**From:** Sue Howell  
**Sent:** 08 November 2017 17:20  
**To:** Planning.Responses  
**Cc:** Simon Davis  
**Subject:** RE: Planning Consultation on BE/106/17/DOC

This application is looking for the discharge of Condition 4 of application BE/106/17/DOC imposed under BE/45/16/PL Landscaping.

**APPLICATION** BE/106/17/DOC

17  
**Site Address:** 27 North Bersted Street Bersted PO22 9AA  
**Description of Works:** Application for approval of details reserved by condition imposed under BE/45/16/PL relating to conditions 3-schedule & samples of materials & finishes, 4-landscaping scheme, 5-details of screen walls and/or fences, 6- vehicle access construction, 7-Construction Management Plan, 8-surface water drainage, 9-details of foul sewerage disposal, 10-maintenance of SUDs system, 11-access & management of any watercourse, 15-details of waste & recycling enclosures & 18-covered & secure cycle parking spaces.

Landscape Drwg No.243/NB/15D Landscape Proposals and Planting scheme Land to the rear of 27 North Bersted Street Bersted Bognor Regis

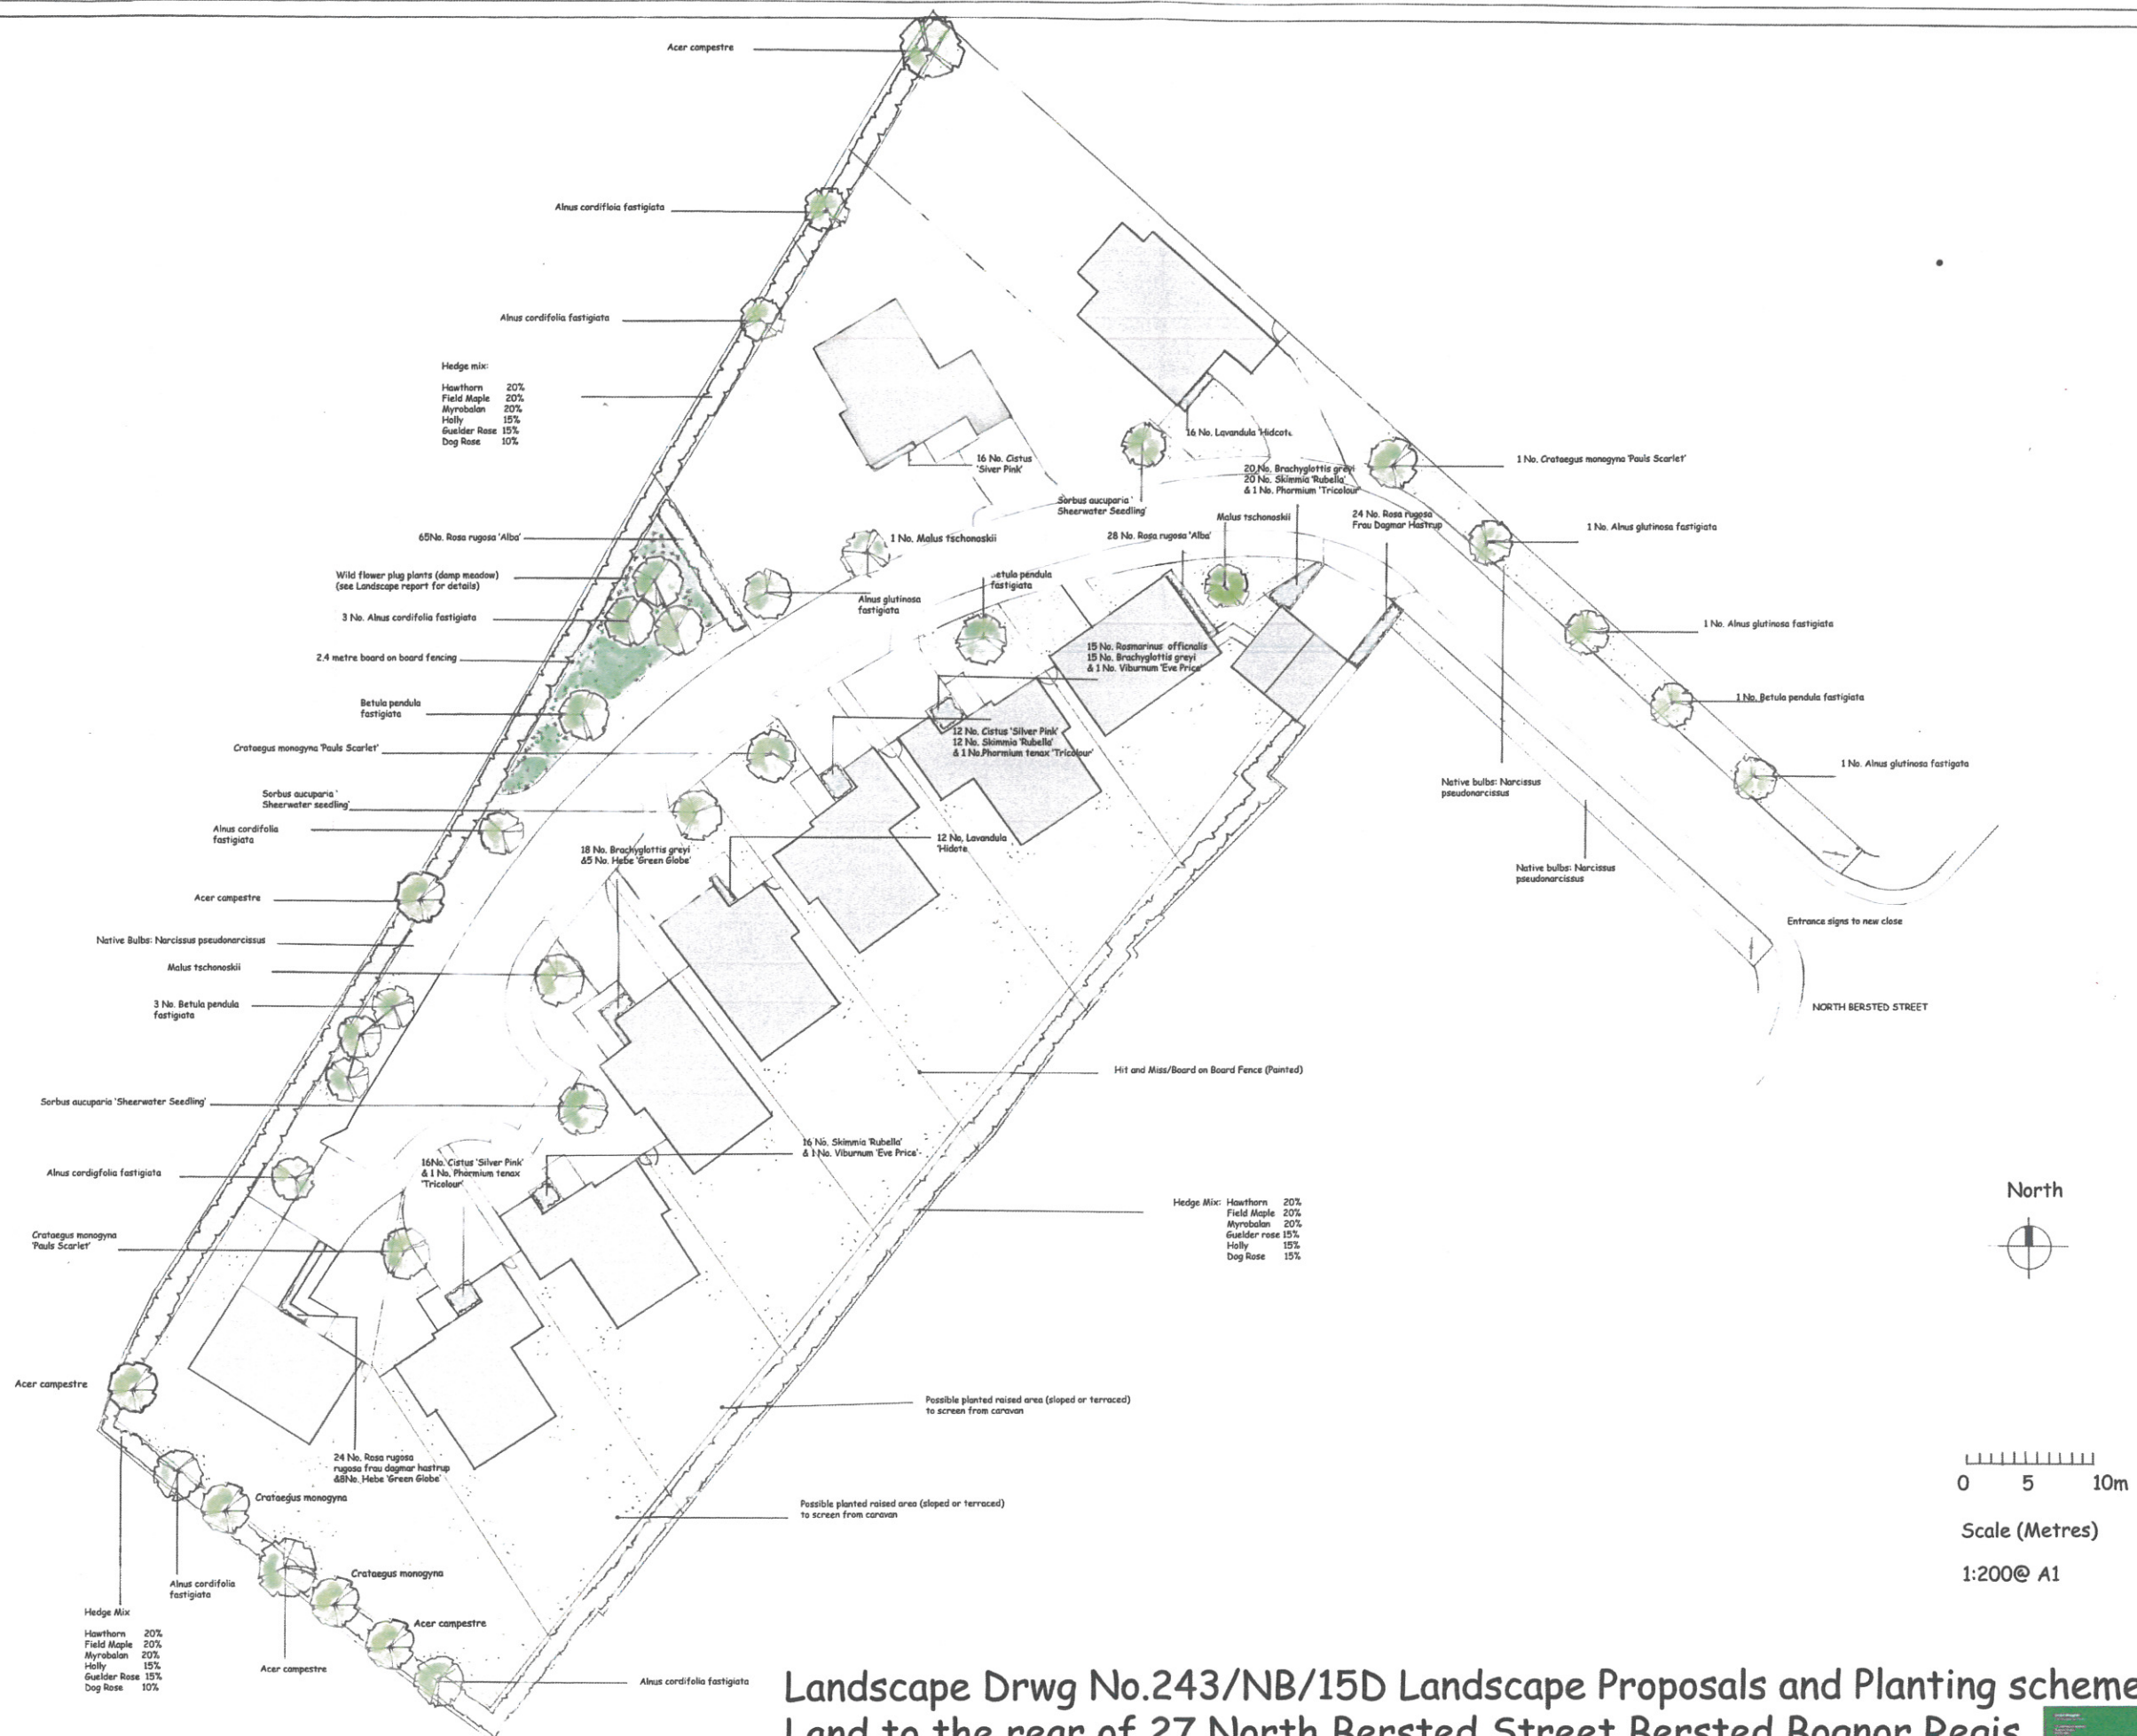
The information provided in landscape proposal plan N.243/NB/15 D landscape proposals and additional information submitted within the landscape design statement does provide a well thought out scheme which is suitable for location and which is sufficient in detail in plan form. The species choice and size at time of planting is suitable for location, we would however require confirmation of the numbers of native hedgerow plants being proposed to the periphery hedgerows and not just the percentage mix as shown, this will allow for the full picture to be seen and the extent of this development edging to be clear.

We would recommend the discharge of Condition 4 on this development as soon as the hedgerow quantity has been submitted and approved.
